MEMO

TO: Jessica Valic, P.Eng. City of Ottawa
FROM: David Feghali, P.Eng. PMP
SUBJECT: 415 Legget Drive Site Redevelopment – Site Grading Plan Review
DATE: June 23, 2022

TITLE:
GRADING PLAN

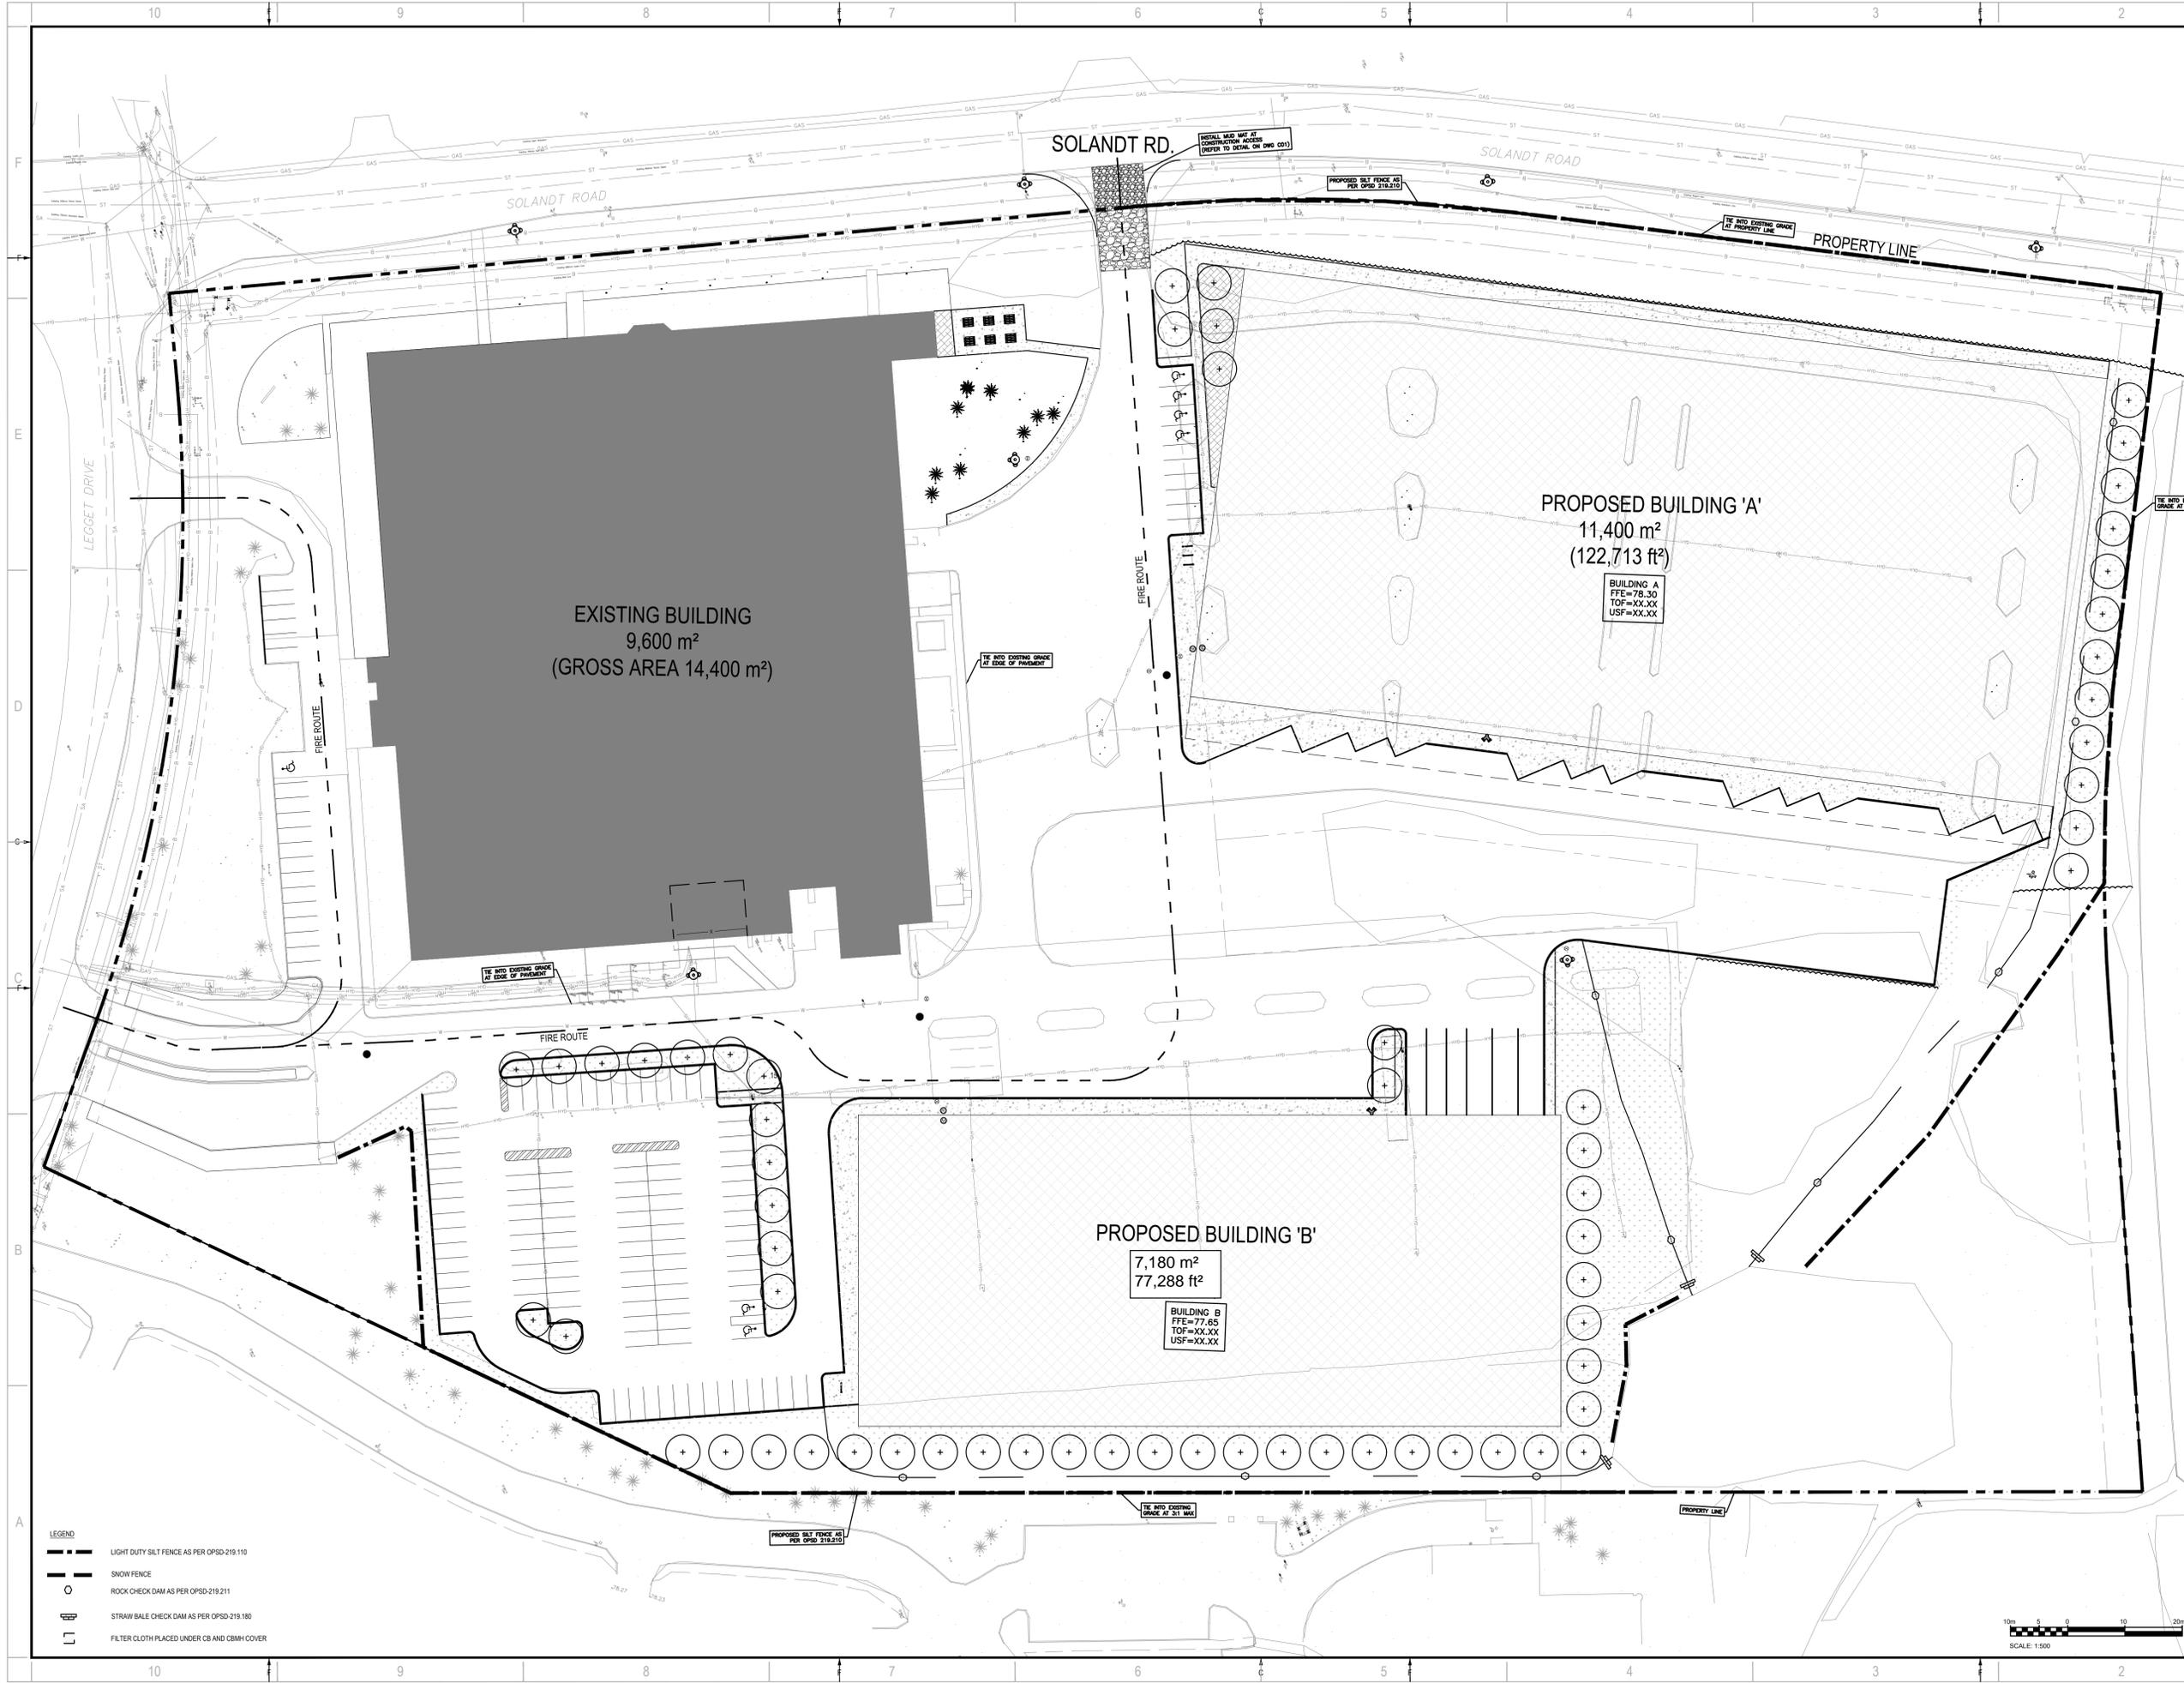
We have reviewed the revised site grading, dated March 18, 2022. The majority of the proposed areas of grade raise are below the permissible limit, however there are some areas where the grade raise restriction of 1 metre is exceeded, such as the north side of Building A along Solandt Road. These areas will need to be composed of light weight fill material. Future revisions of this grade plan will need to show this lightweight fill material requirement. Additional geotechnical review is suggested to ensure such filling requirements are included on future grading and structural plans.
